**Re: Curl Curl North Public School Redevelopment, Playfair Road North Curl Curl
(SSD 8310) Response to Submissions**

I refer to your letter dated 12 June 2018 containing details of the proposed amendments to the redevelopment of Curl Curl North Public School.

Council has reviewed the amended documentation and would like to provide the following comments:

Date	MAY 2018	Approved	S.D.C	Verified	A.P	Prepared	J.K
Scale @ B1	1:200, 20		02.05.18		02.05.18		02.05.18
Job number	16-258	Drawing number	SW2			Amendment

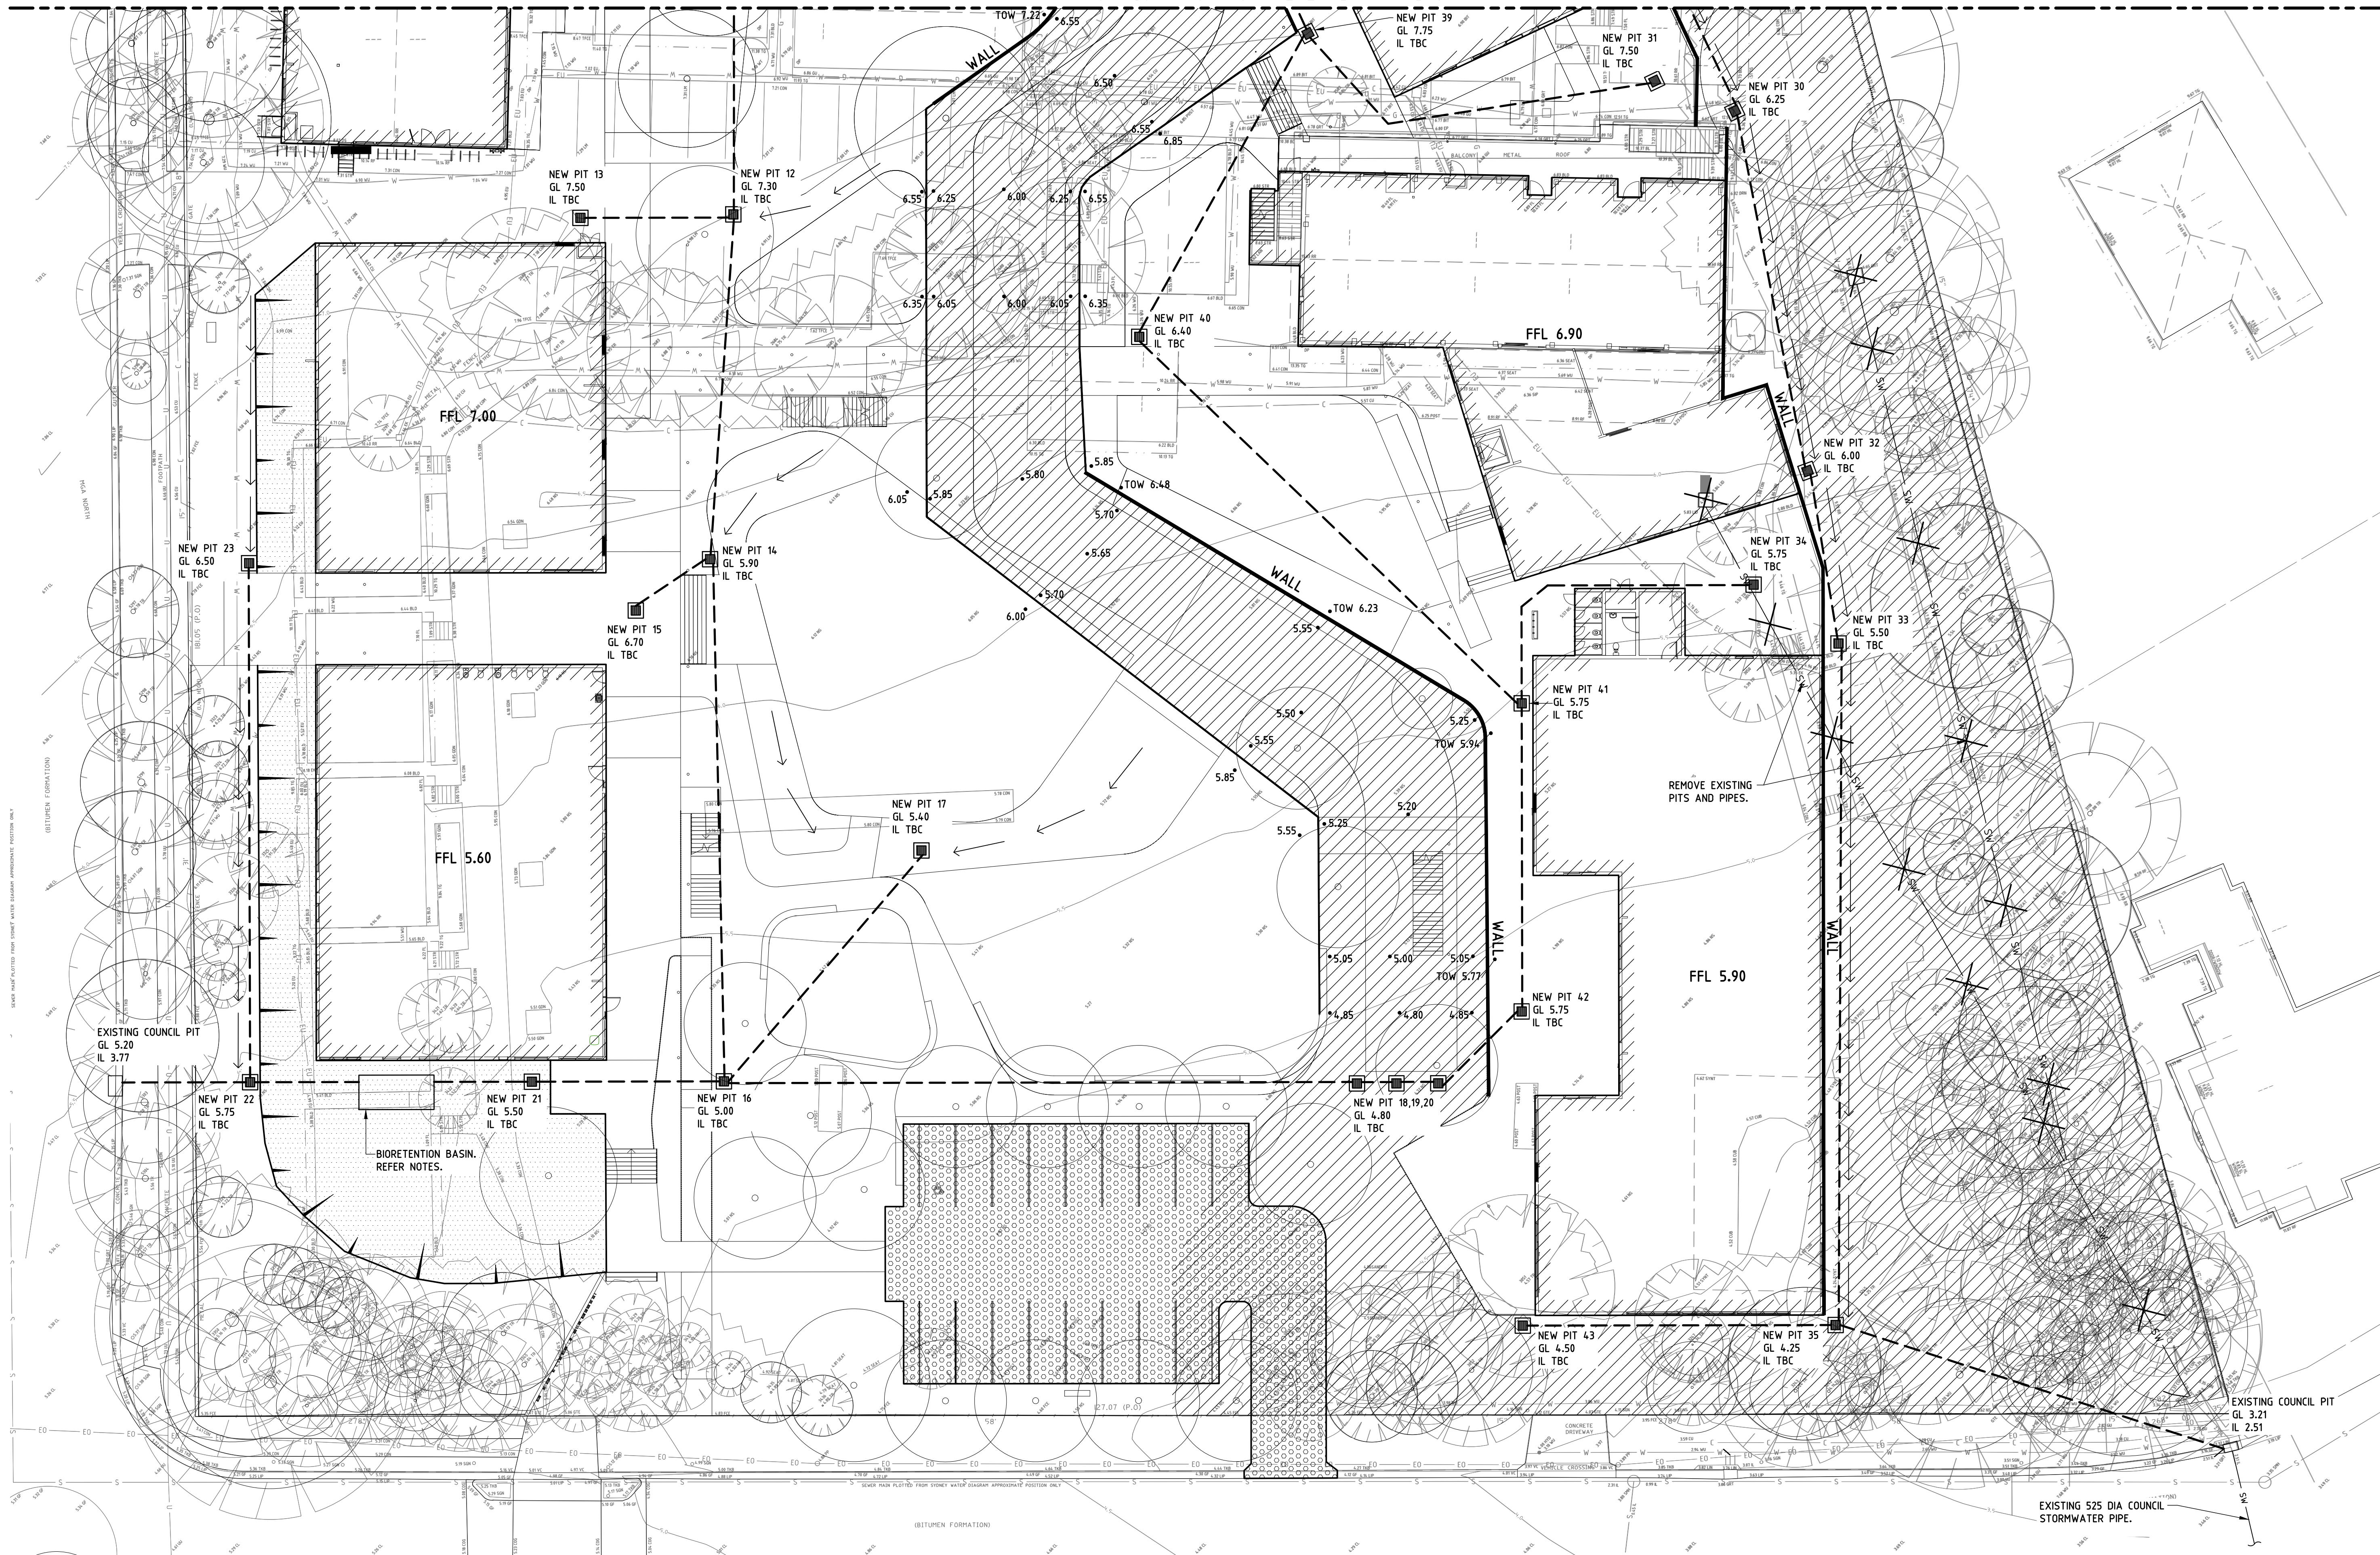
The Woolacotts stormwater management report has addressed the previous concerns raised in relation to the impacts of upstream overland flow on the redevelopment and stormwater discharge points.

The Woolacotts stormwater management report details two constructed overland flow paths through the site which are appropriately landscaped and achieve depth versus velocity requirements in accordance the Floodplain Development Manual.

The 750 mm Council pipeline that runs adjacent to the north eastern boundary was not located by survey however relevant conditions to locate the pipeline and compliance with Councils Water Management Policy, specifically in regards to building over or adjacent to Council pipelines and easements have been included.

All structures are to be located clear of Council's 750mm pipeline. Footings of any structure adjacent to an easement or pipeline are to be designed in accordance with Council's Water Management Policy; (in particular Section 6 - Building Over or Adjacent to Constructed Council Drainage Systems and Easements Technical Specification). Any proposed landscaping within a Council easement or over a drainage system is to consist of ground cover or turf only.

Council's 750mm pipeline located adjacent to the north eastern boundary is to be located by survey undertaken by a registered surveyor and a copy provided to Council prior to the commencement of any works.

The Stormwater Management system including or proposed overland flow paths is to be designed and constructed in accordance with the stormwater management report and concept drainage layout plans prepared by Woolacotts dated 16 May 2018 (ref 16-258).
